RFI #: 44
 Date: 1/27/2012
 Job: EB-02 Keller Springs Lofts
 Phone: 877-777-5115

Subject: Conflict with floor plan on A1 all A unit

RFI #: 125
 Date: 5/21/2012
 Job: EB-02 Keller Springs Lofts
 Phone: 877-777-5115

Subject: A1 and A1-HC Unit Questions

SHEET NUMBER
2.2HC
A1-HC UNIT

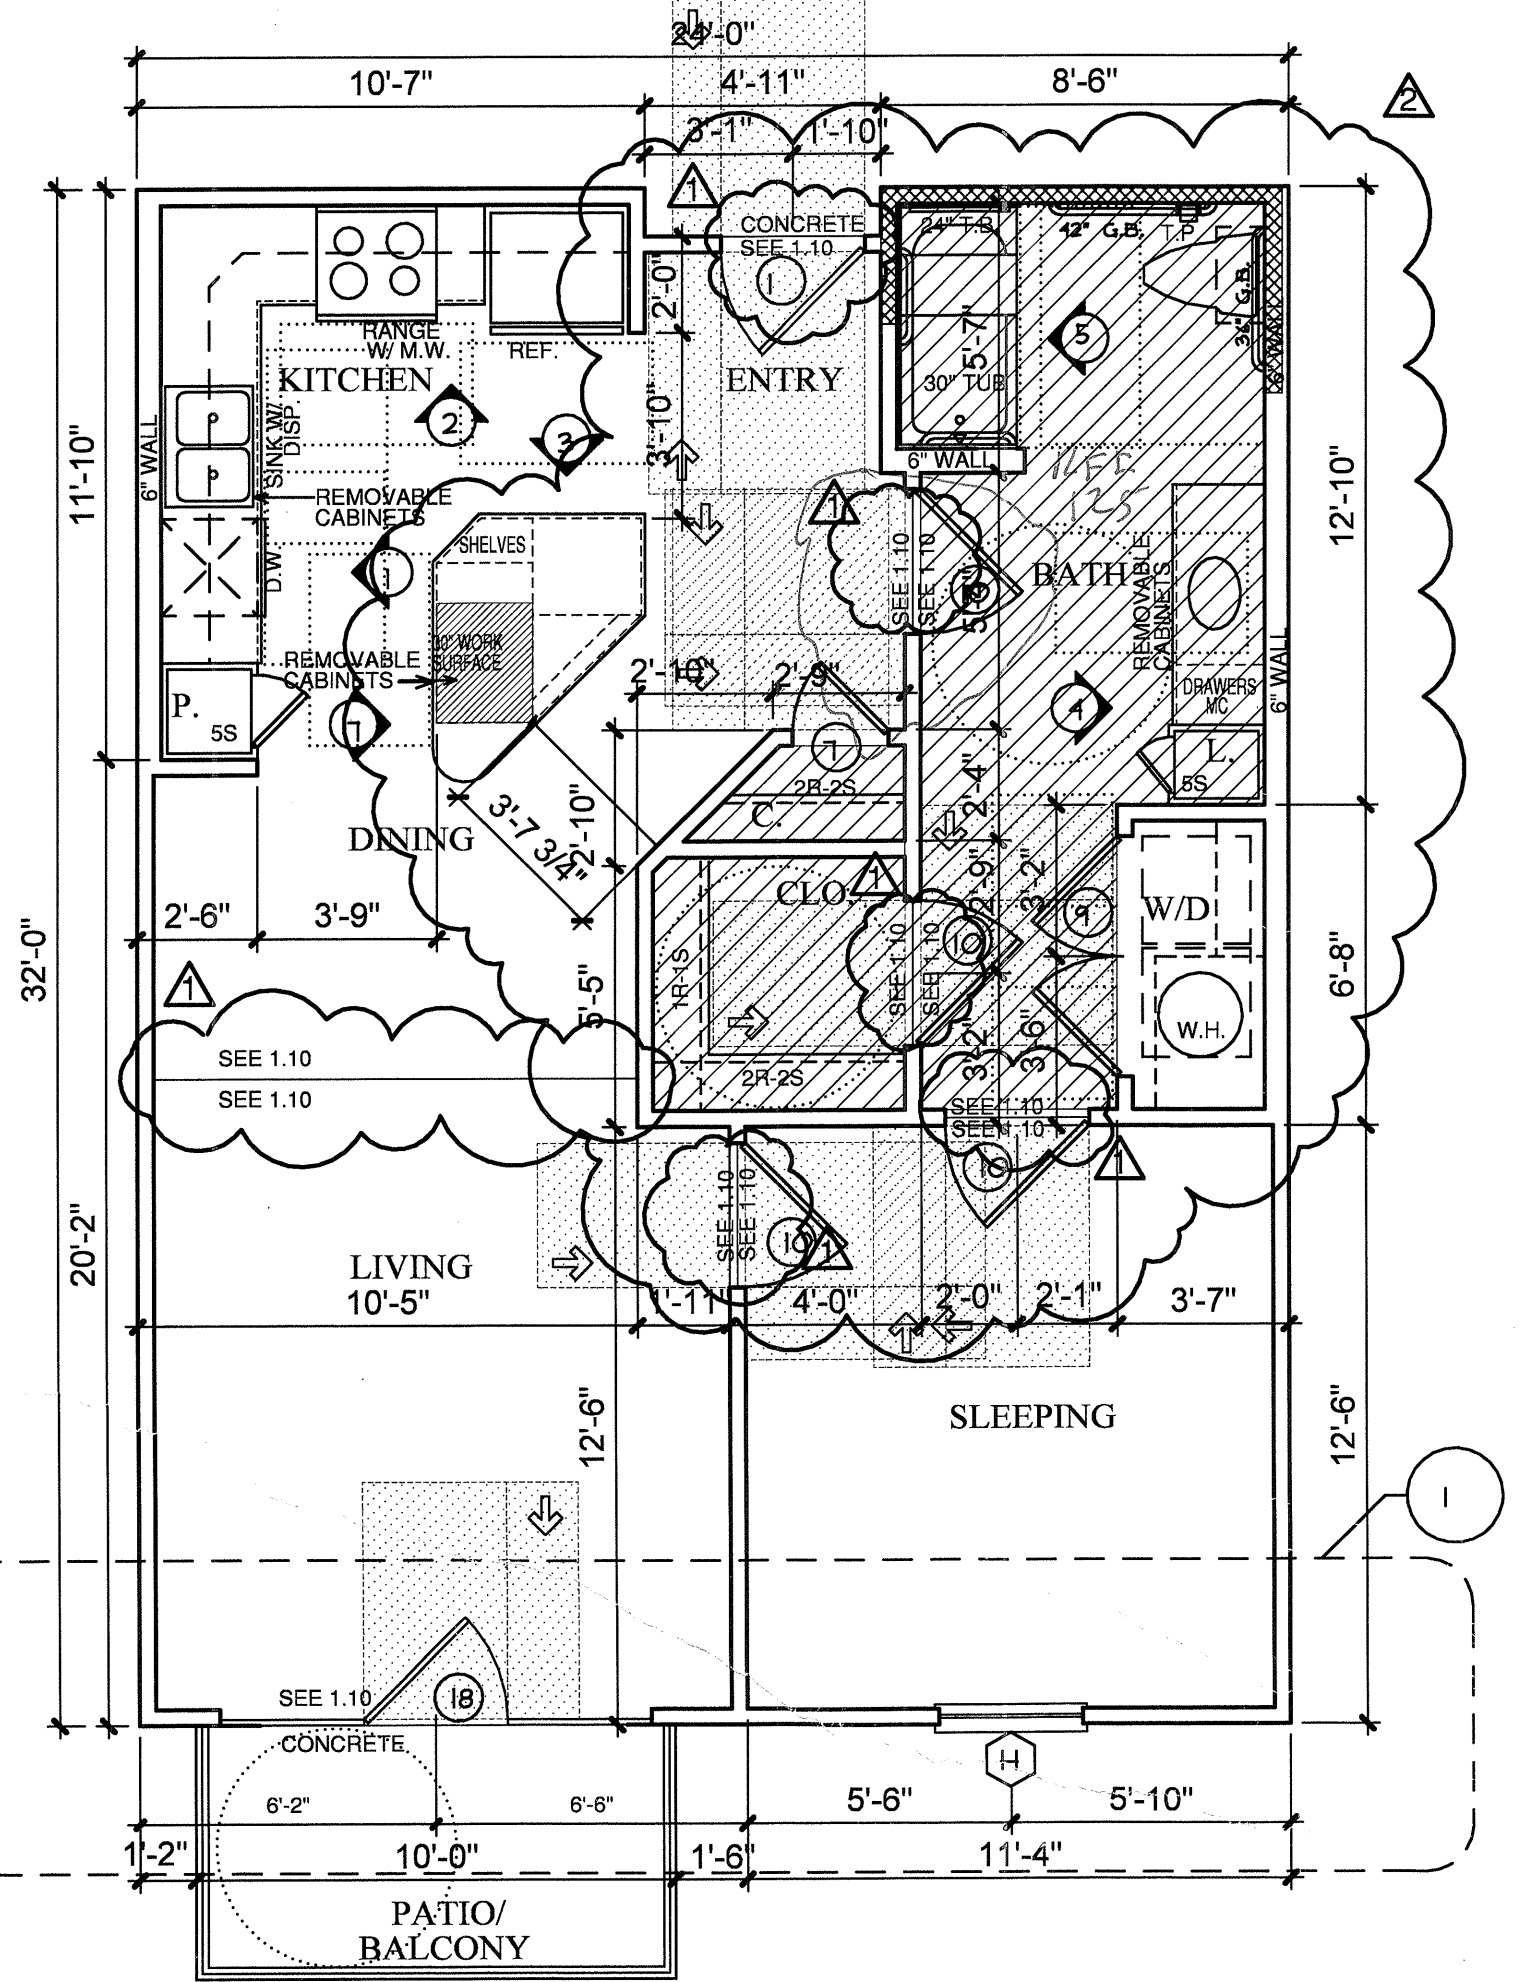
Request: A1 Unit - Please provide length of wall dimension for wall that separates vanity and toilet. A1HC Unit - Please provide door number for bathroom door from the kitchen area. Also provide dimensions for where the door sits.
Date Required: 5/29/2012

Response: The wall in the A1 unit is 2'-1". The door tag in A1HC is 10. Off the plumbing wall where the tub is, the wall is 4" for the door frame, the door is 3'-0", then there is 2'-0" till the wall where the closet door is. The dimension text that is on top of the door tag says 5'-4".

SHEET NUMBER  
**3.2C**

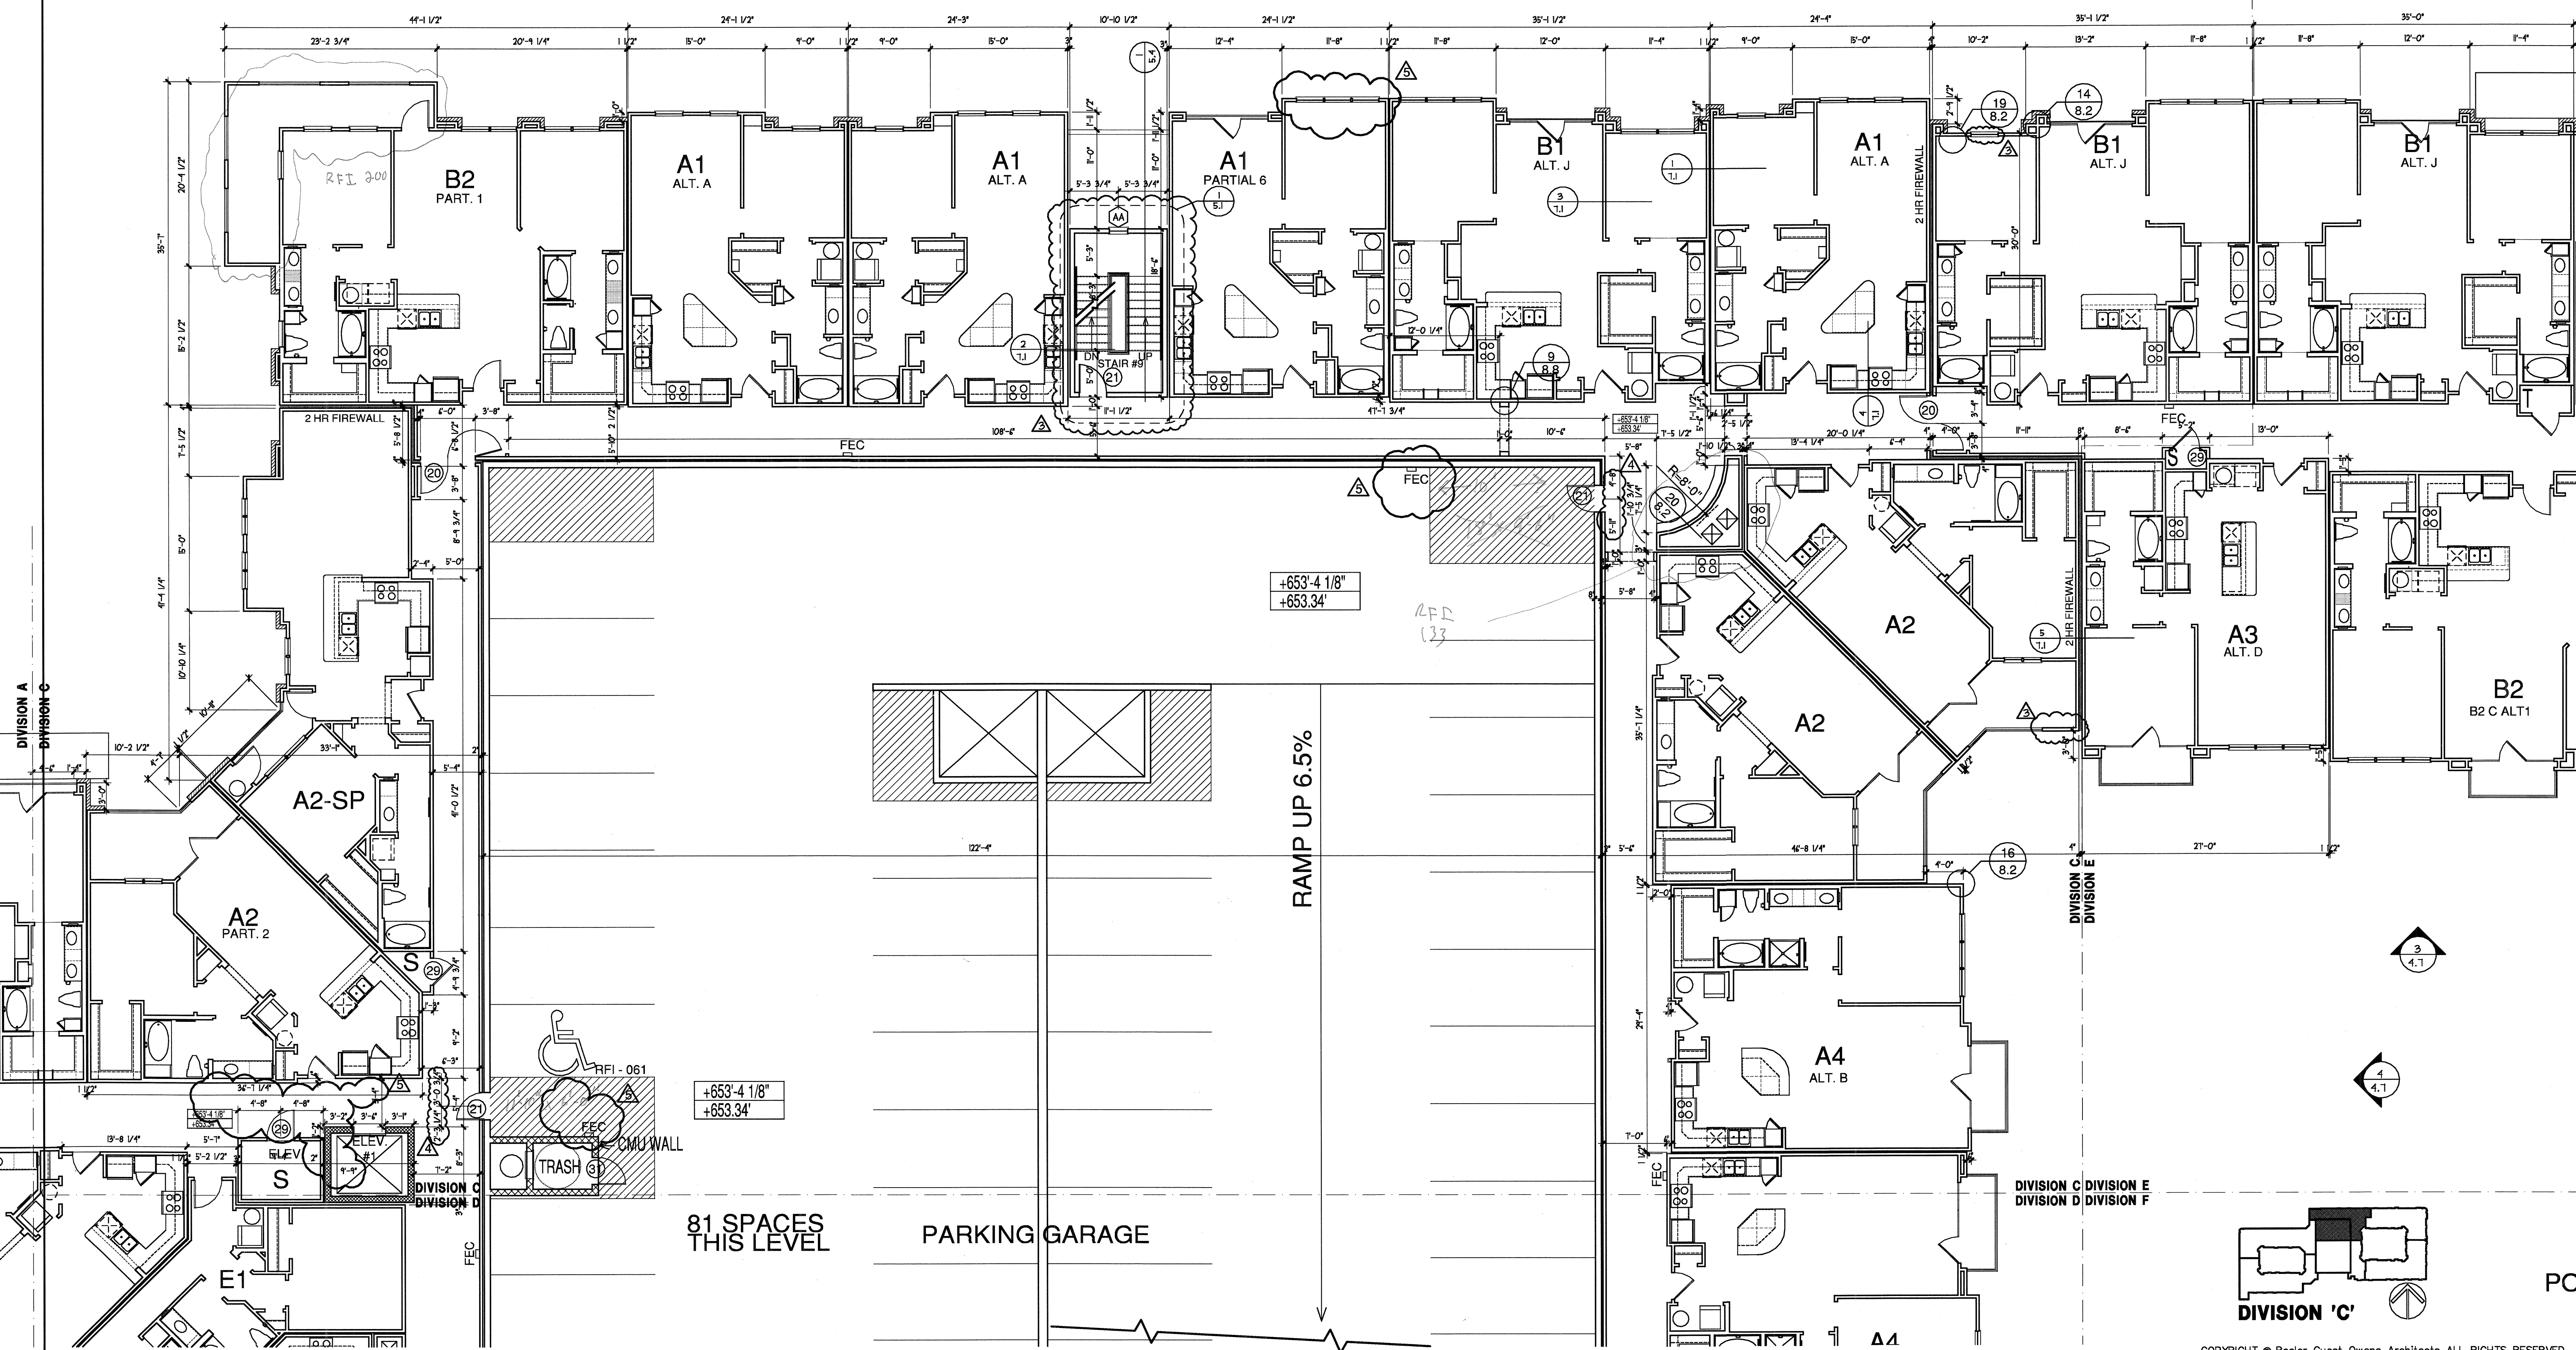
Request: Erik there is a conflict on A1 part 5 (1st floor) and A2 part 6 (2-4 floors). 2/4.4 shows these units to the left of stair tower #9 elevation clearly shows these windows matching the B mark windows of the adjoining B1 units. However, 12/2.2 and 13/2.2 calls out mark 17 which is 3x6' 8" triple fixed french doors. Please see attachments.
Date Required: 2/6/2012

Response: The elevation is drawn accurately per the design intent. The plans have been updated.

see next page.
